Bryan G Norman, B.Sc. (Est Man.) F.R.I.C.S
Summary of Submission to Planning Inspectorate
Ref A303, Sparkford to Ilchester Dualling

1. The design of Hazlegrove junction.
2. The omission of a parallel road.

**ENGINEERING SECTIONS
SLIP ROADS**

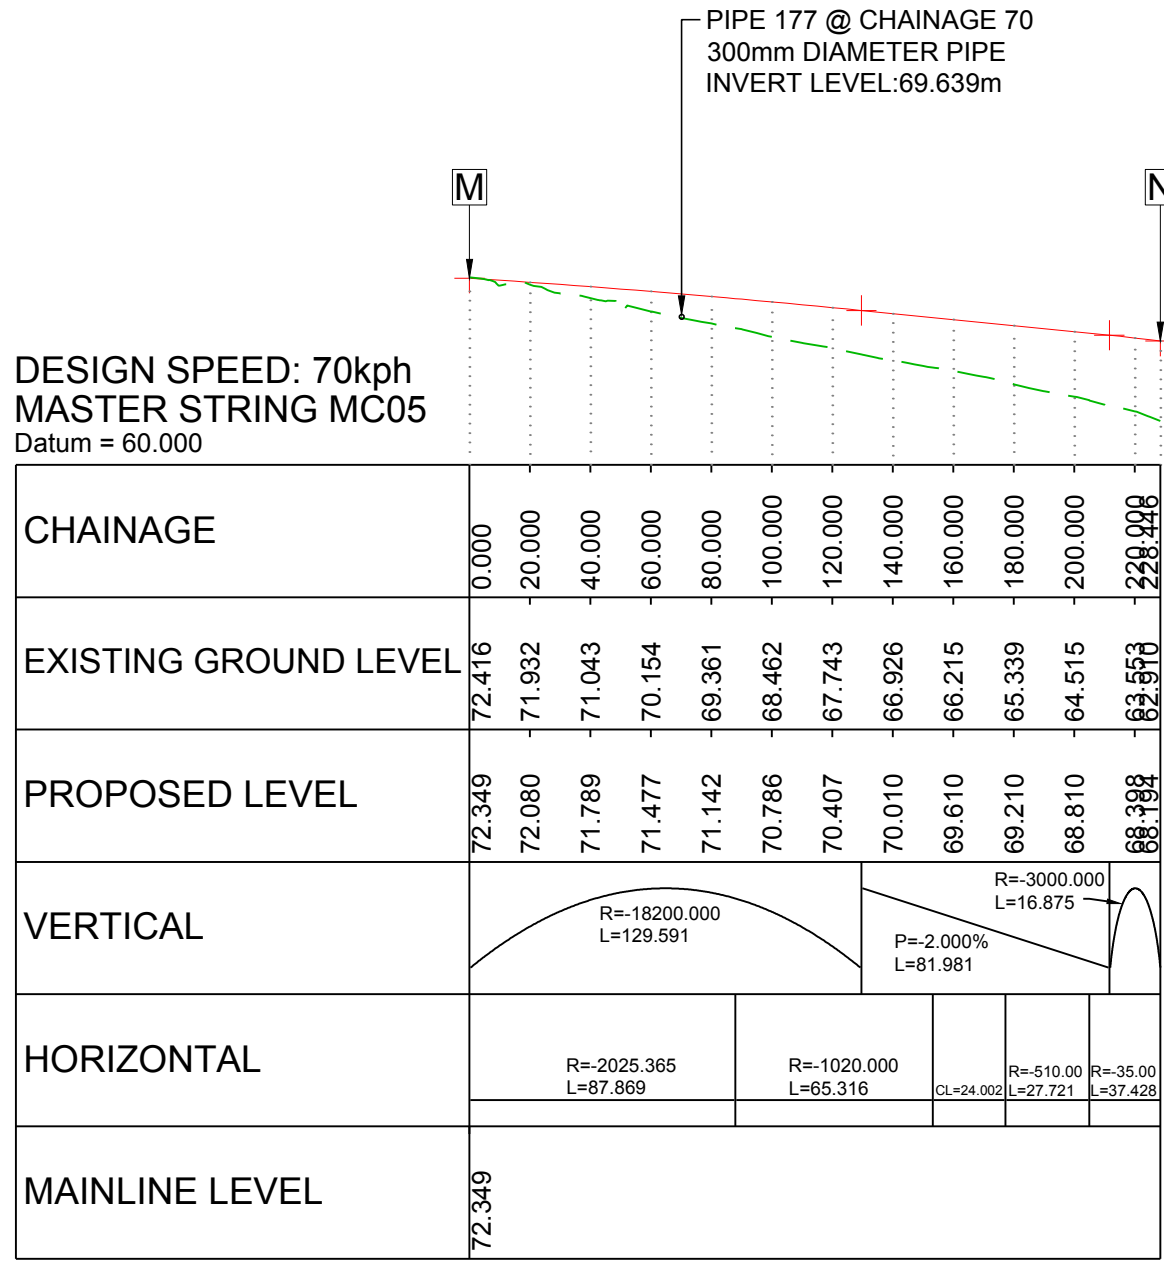
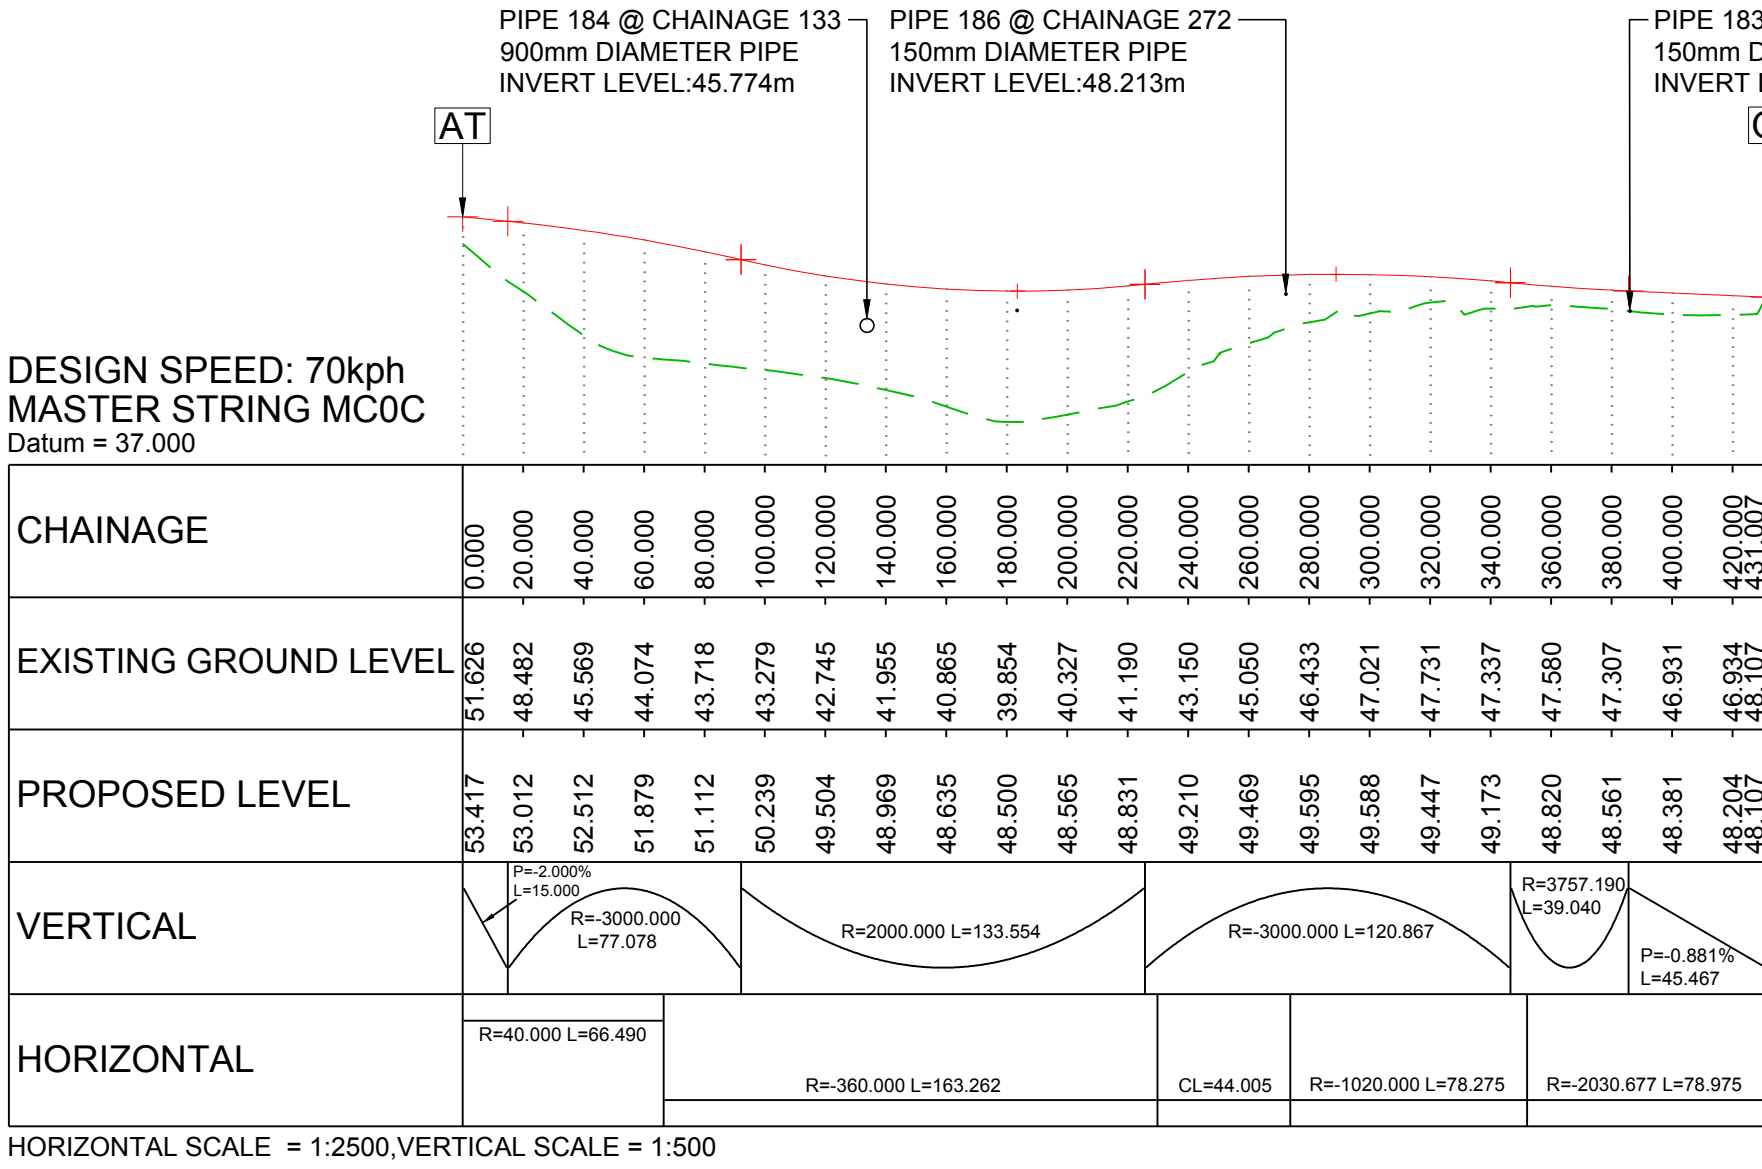
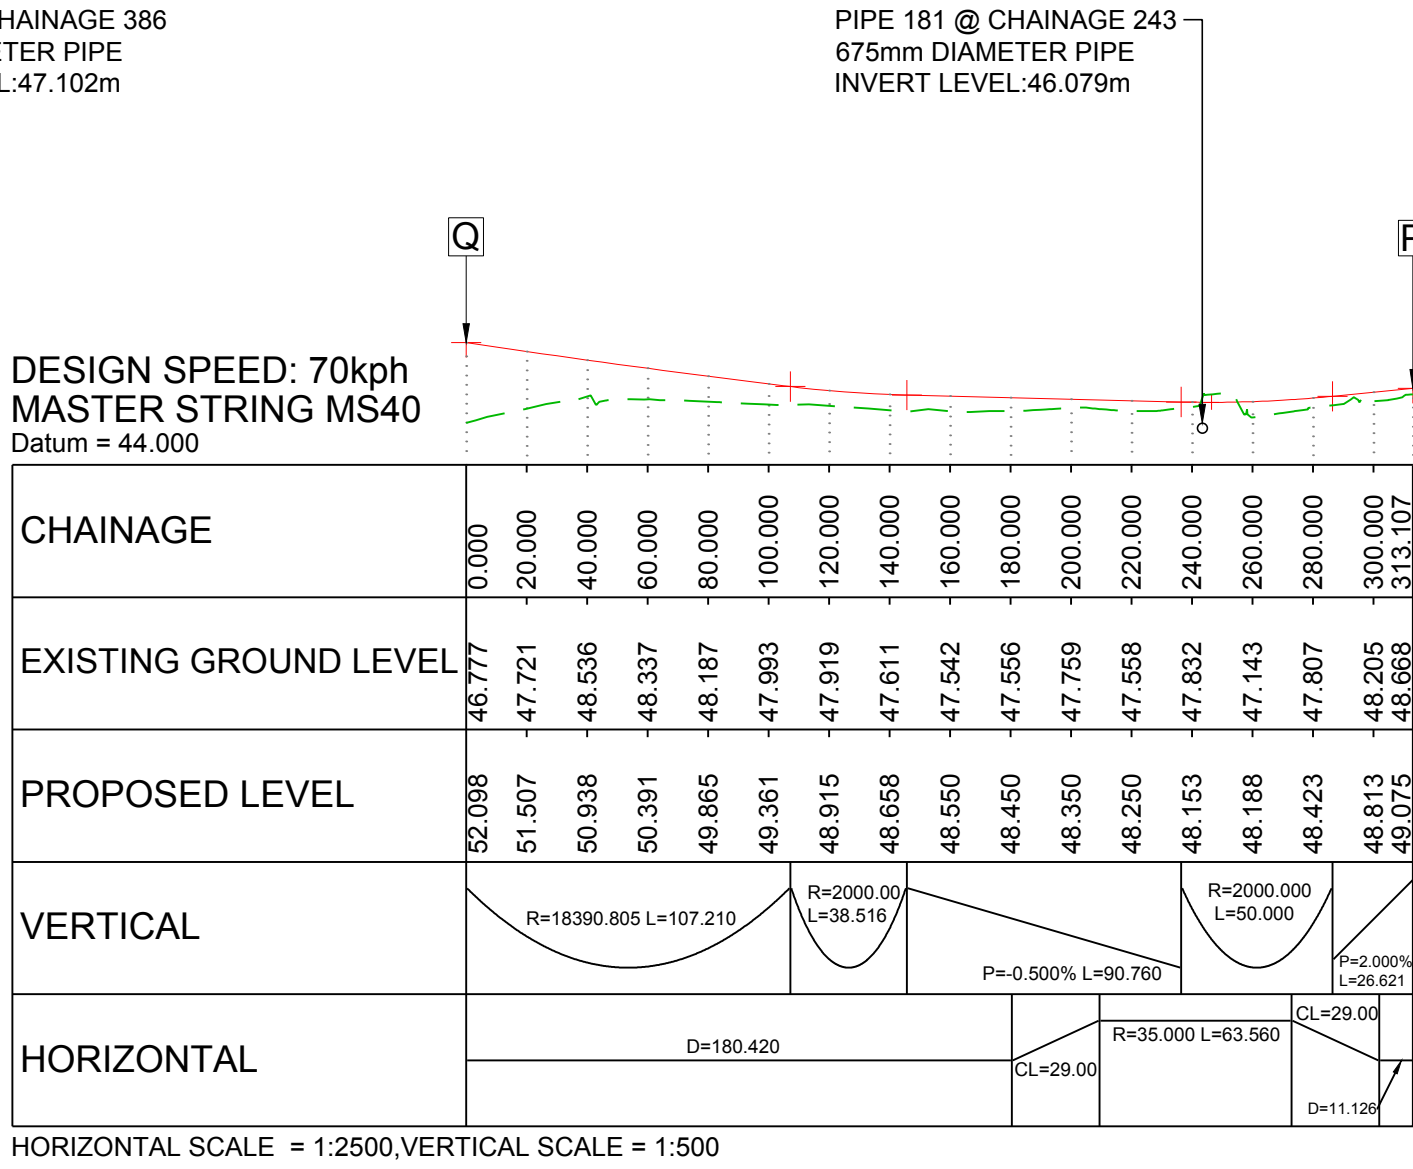
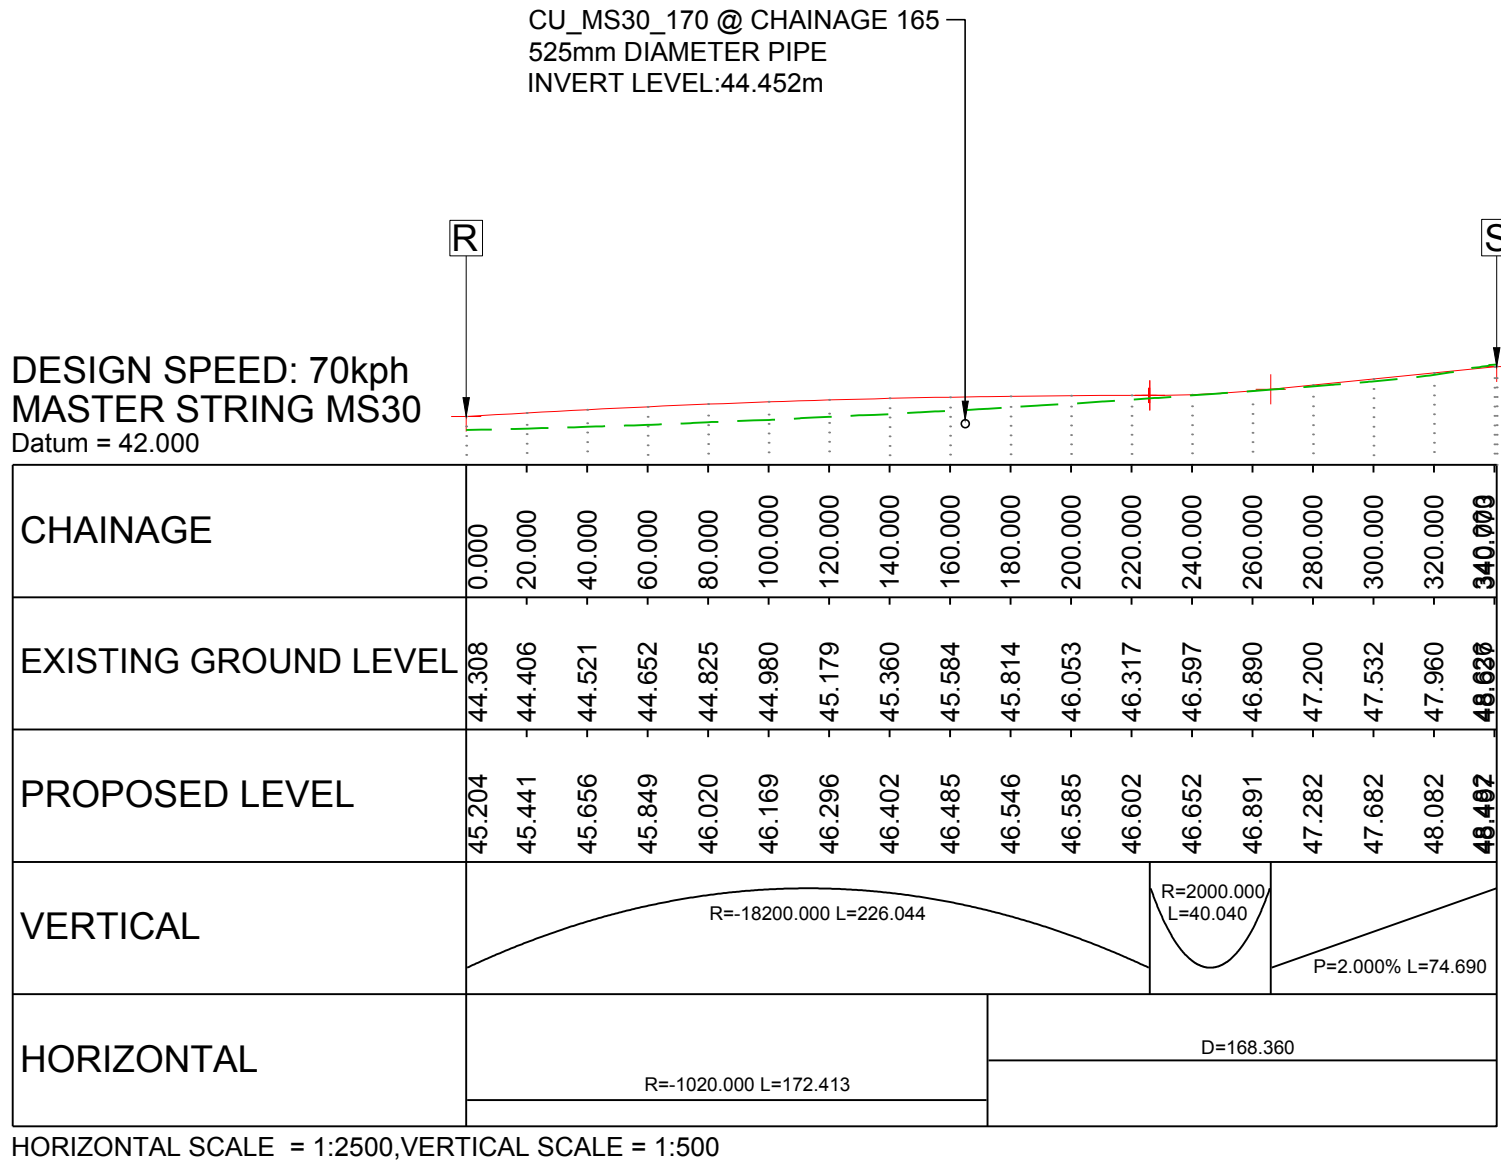
1. The much simplified design of the junction substantially reduces the land used within the Registered Park from 2.6 Hectares (H) to 0.9H and uses lower ground. It avoids creating 1 million kilometres of unnecessary travel per annum and grid-lock at peak periods caused by the failure of the existing design to take account of the schools traffic impact. It is, therefore an environmental improvement of considerable importance and will provide a substantial direct savings in construction in the order of £9M, plus a further £7M indirect savings.
